Our Ref: BR/233/19/PL

**Town & Country Planning Act 1990 (as amended)
Town and Country Planning (Development Management Procedure) (England) Order 2015
Application for Full Planning Permission**

Development Part change of use of ground floor & formation of a first floor rear extension to create 2 No self-contained studio flats with associated refuse/ recycling & cycle store (resubmission following BR/63/18/PL).

Location 77 Aldwick Road Bognor Regis

Component: **Elevation of New Gate**

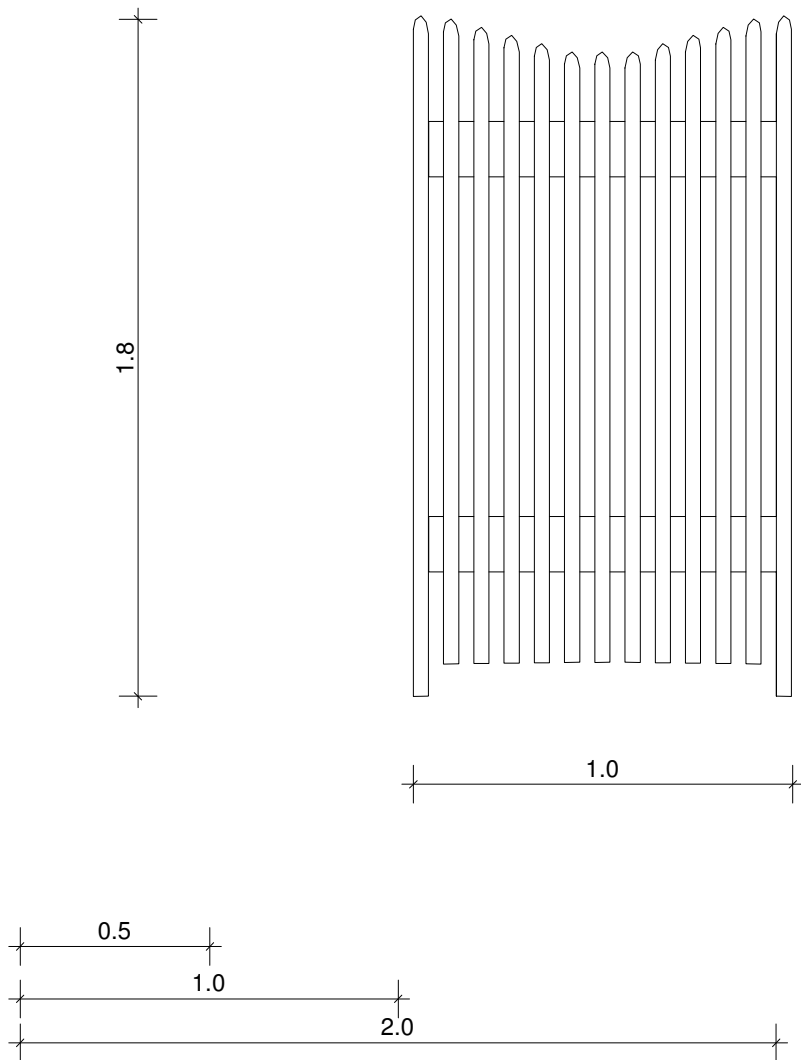
Please provide an elevation of the new gate.
